From: Plant, Tom - Communities <Tom.Plant@Oxfordshire.gov.uk>
Sent: 20 May 2019 11:38
To: Bob Neville
Cc: Cllr Arash Ali Fatemian; DC Support
Subject: 19-00619-F - Land East Of The Leys Adderbury

Planning application:	19/00619/F
Location:	Land East Of The Leys Adderbury
Description:	Erection of 3 No dwellings on land east of The Leys, Adderbury
Type:	Full Development
Case Officer:	Bob Neville

Oxfordshire County Council, as the Local Highways Authority, hereby notify the District Planning Authority that they **object** to the granting of planning permission.

**SITE LAYOUT PLAN**

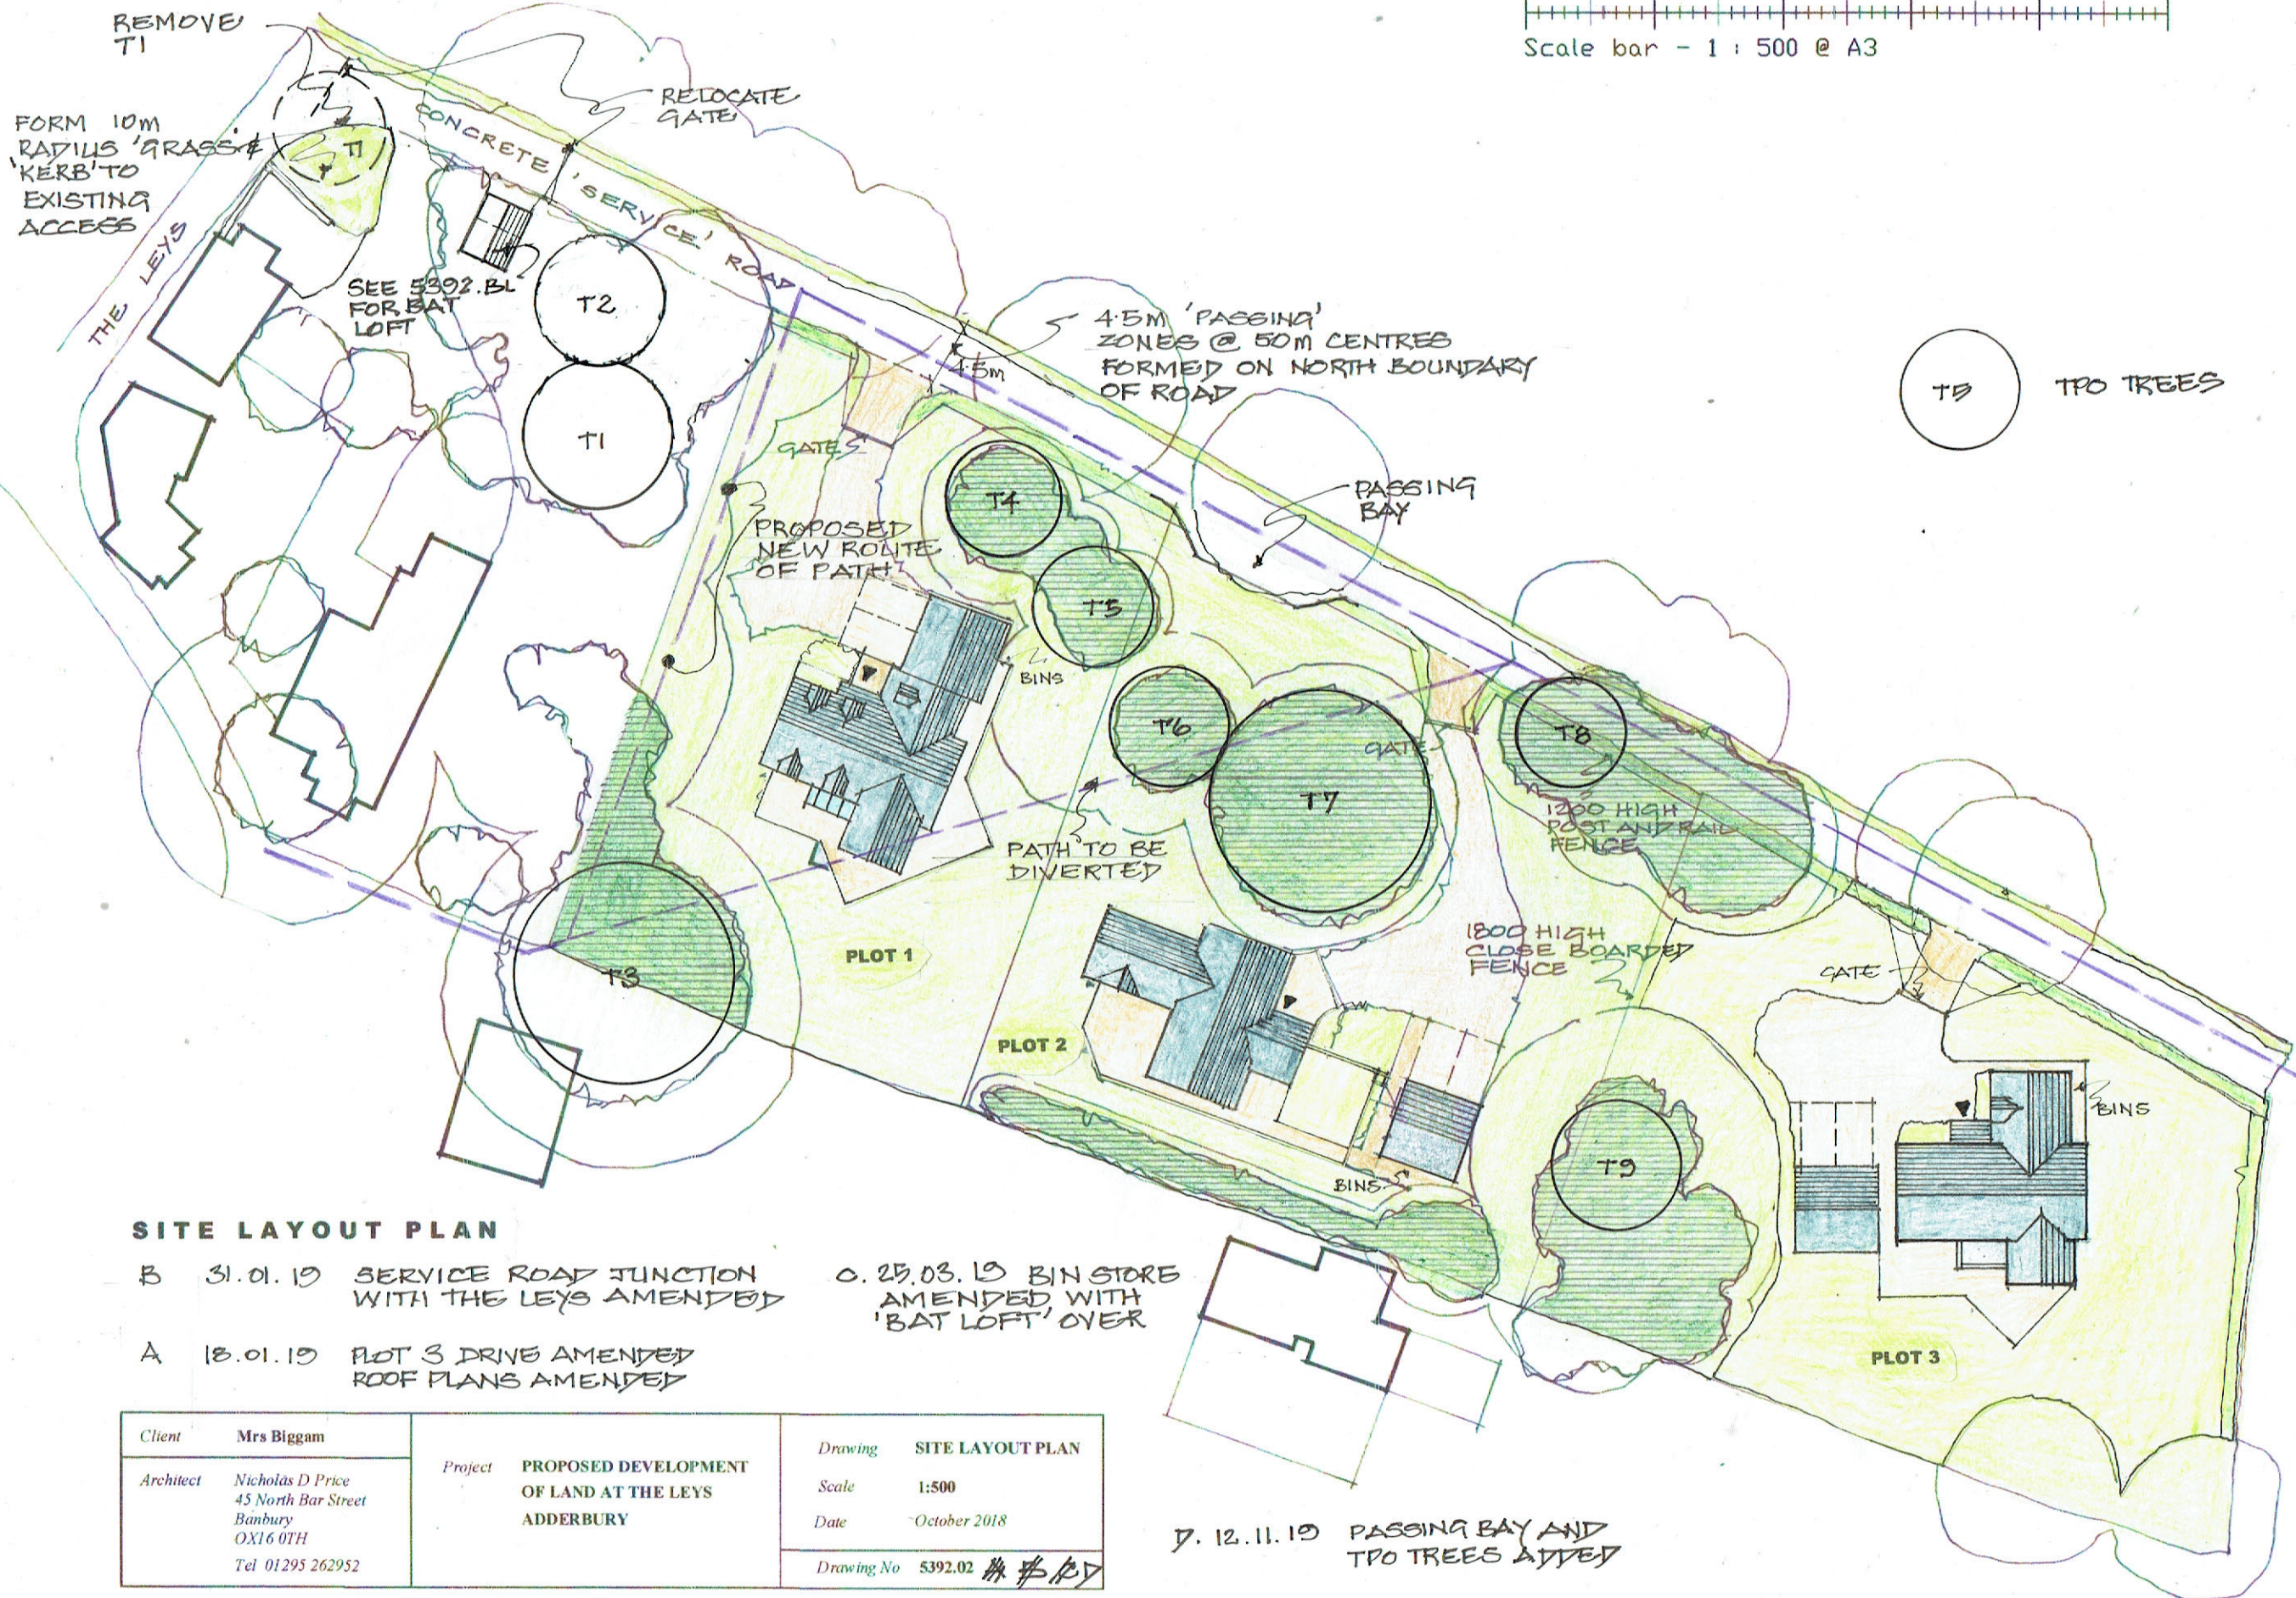
The proposals access is off The Leys which incorporates a very tight 90 degree bend which severely restricts forward visibility. It is my understanding that the service road is used by Thames Water to access a pumping station that is at the end of the, The Leys.

Whilst I accept The Leys is used for utilities and a single dwelling to be accessed, any intensification of The Leys with three dwellings will present a highway safety concern with the possibility of vehicles giving way to one another and potentially relying upon either road users who are traveling in opposing directions to reverse back to a safe point to allow one user to pass the other safely. I understand from my colleague Beth Rutterford that Adderbury 5 footpath runs through and along the service road. I would have concerns therefore with potential new residents having to reverse to give way to oncoming traffic with the potential of pedestrians using the same space as road users and the conflict that this will give rise too.

From looking at the proposed site layout, the actual plots look acceptable with a suitable turning area within the plot to allow vehicles to access and egress in a forward driving gear.

Were this scheme to be approved I would be looking for suitable passing places along the service road so the conflict of potential reversing along the road is designed out and will allow a safe and suitable access to the site for residents, utilities and pedestrians.
